Our ref: NO/2014/106765/01-L01
Your ref: 3/2014/0561
Date: 25 July 2014

PHASE 4 OF PROPOSED DAIRY UNIT. STEEL PORTAL FRAME AGRICULTURAL BUILDING WHICH WILL ACCOMMODATE 2 ROBOTS, DAIRY, CATTLE CRUSH, AI AND CATTLE HANDLING FACILITIES

DEMENSE FARM, SETTLE ROAD, NEWSHOLME, GISBURN, BB7 4JF

Title: Proposed Site Plan of Phase 4 of
Agricultural Building.

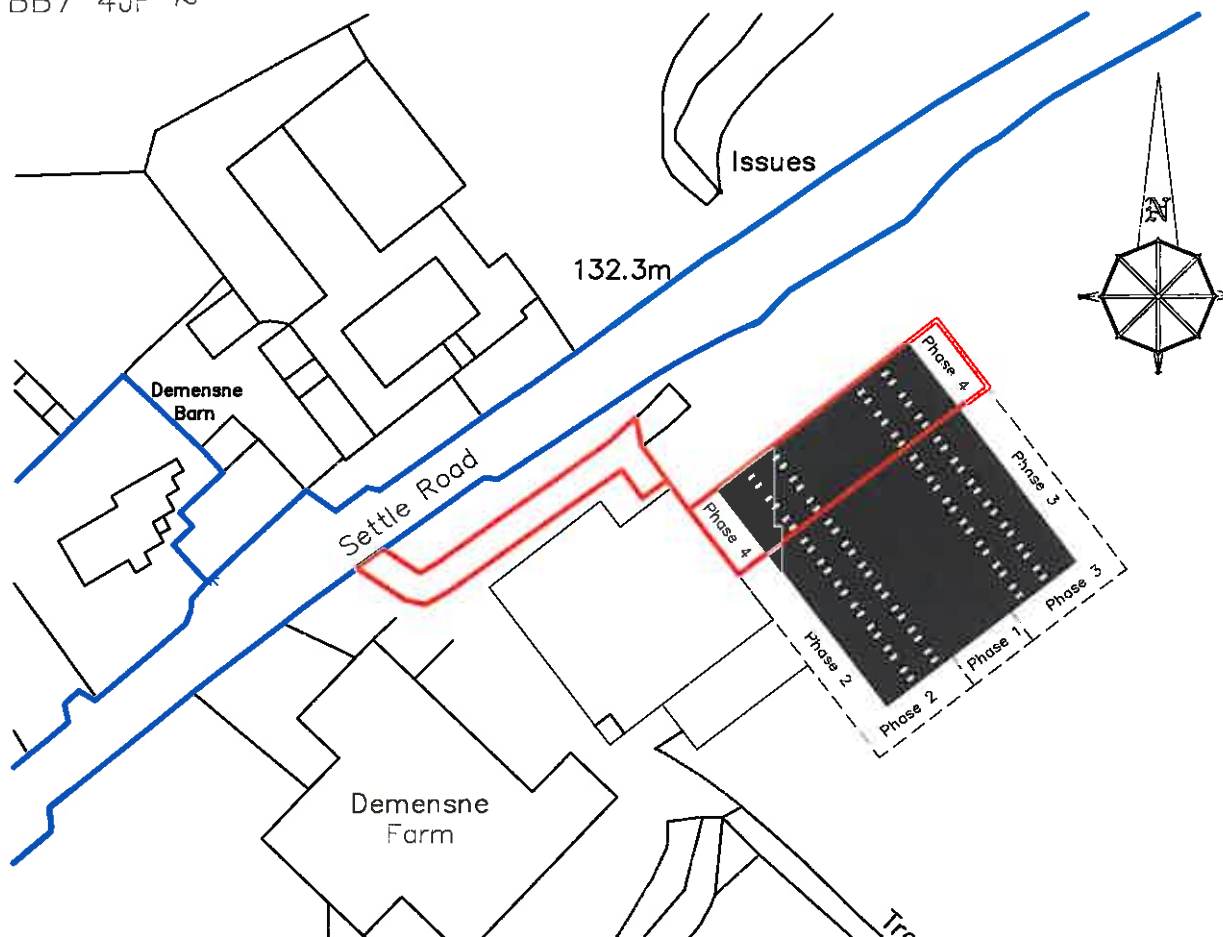
No information has been supplied with regard to foul and surface water drainage of the proposals, therefore we advise that only clean water should be discharged to surface or ground water. The Environmental Permitting Regulations 2010 make it an offence to cause or knowingly permit any discharge that will result in the input of pollutants to ground or surface waters.

There are surface water and groundwater receptors present in this site setting. The site is located on a Secondary A limestone aquifer and close to the River Ribble with a tributary of the river issuing adjacent to the northern site boundary.

The previous land use, which includes a disused slurry lagoon, may have caused contamination to be present on the site therefore we recommend that, as a minimum, an appropriate desk study assessment should be completed to determine the potential impact on controlled waters.

CONDITION No development approved by this planning permission (or such other date or stage in development as may be agreed in writing with the Local Planning Authority), shall take place until a scheme that includes the following components to deal with the risks associated with contamination of the site shall each be submitted to and approved, in writing, by the local planning authority:

1. A preliminary risk assessment which has identified:
 - all previous uses
 - potential contaminants associated with those uses
 - a conceptual model of the site indicating sources, pathways and receptors

- potentially unacceptable risks arising from contamination at the site.
2. A site investigation scheme, based on (1) to provide information for a detailed assessment of the risk to all receptors that may be affected, including those off site.

3. The results of the site investigation and detailed risk assessment referred to in (2) and, based on these, an options appraisal and remediation strategy giving full details of the remediation measures required and how they are to be undertaken.

4. A verification plan providing details of the data that will be collected in order to demonstrate that the works set out in the remediation strategy in (3) are complete and identifying any requirements for longer-term monitoring of pollutant linkages, maintenance and arrangements for contingency action.
